Your Ref: OWPC16214
Our Ref: FP/259/17/HH 16-10-2017
Please ask for:
Mark Jones

Two storey rear infill & two storey side extension for loft conversion with 2 No. dormers at rear & 1 No. dormer to front.

22 North Way Felpham

Thank you for your internet representation made on 8th November 2017 which has been recorded as '**an objection**' with the comments as follows:

PROPOSED PLANS

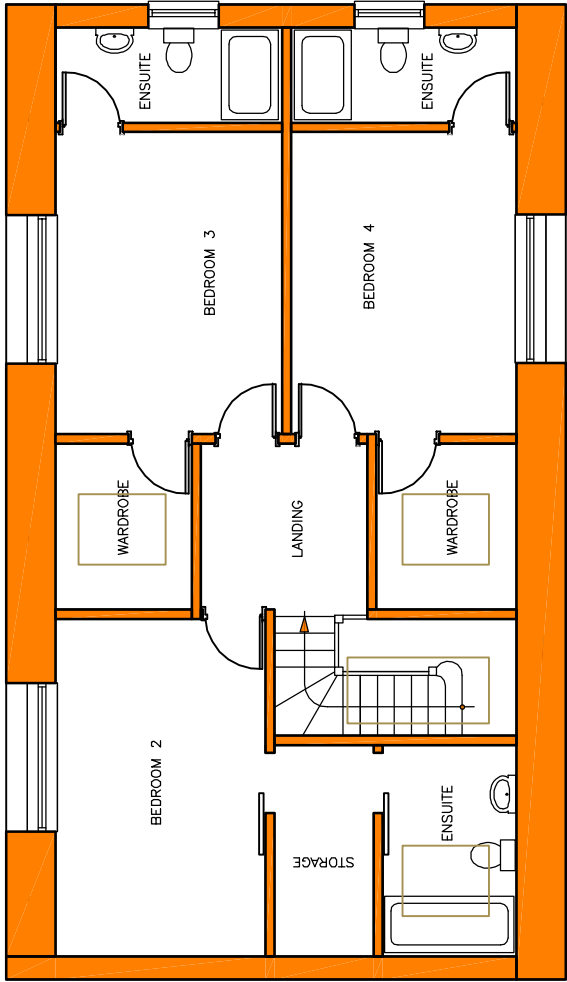
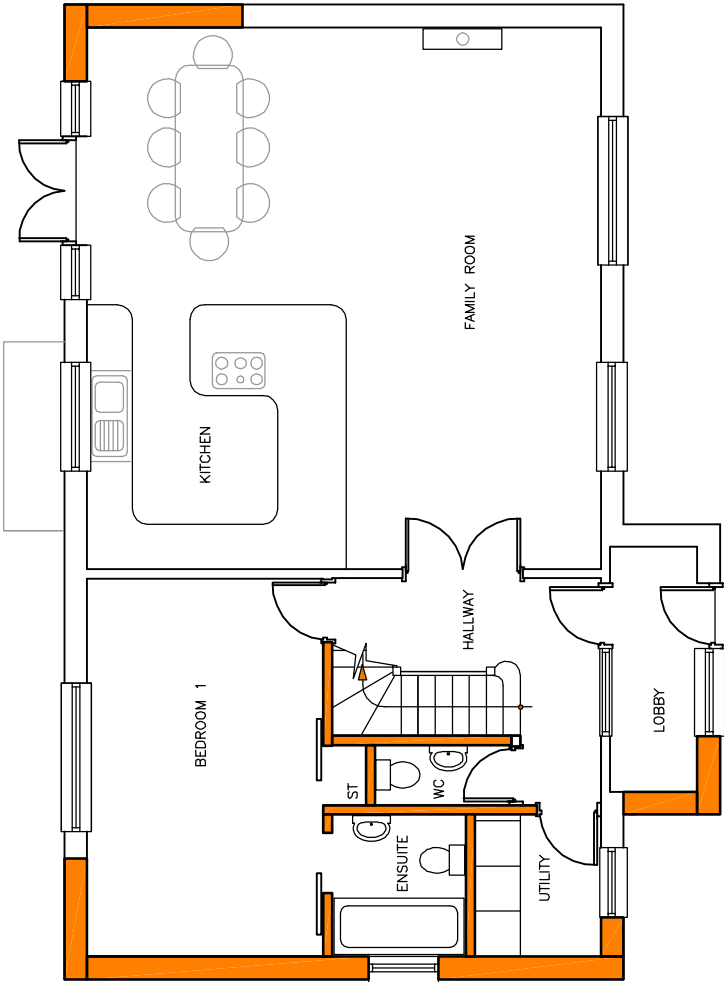
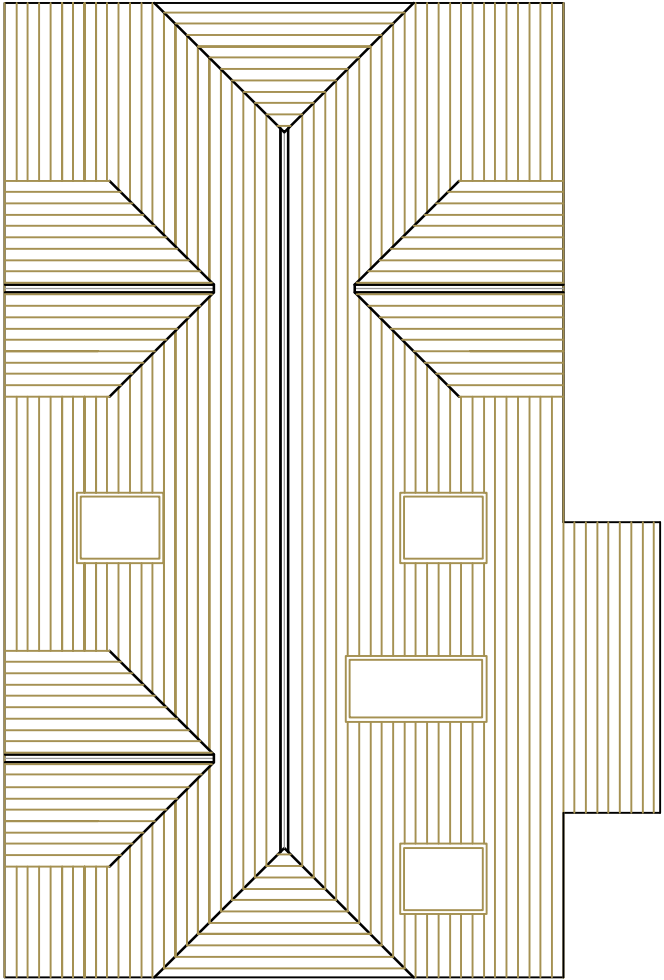
The plans do away with the current garage and increase the number of bedrooms to 4.

The drive is too short but to accommodate the smallest of cars.

As there is no provision for parking I am seriously concerned as if cars are parked outside of the property in increased numbers in a very narrow road it will in fact make my drive way unusable as it needs the full width of the road to both exit and reverse in to my drive safely.

In my opinion this development should not be permitted or at the very least parking restriction such as double yellow line should be imposed for the full length of the property to make parking in front of the property unlawful.
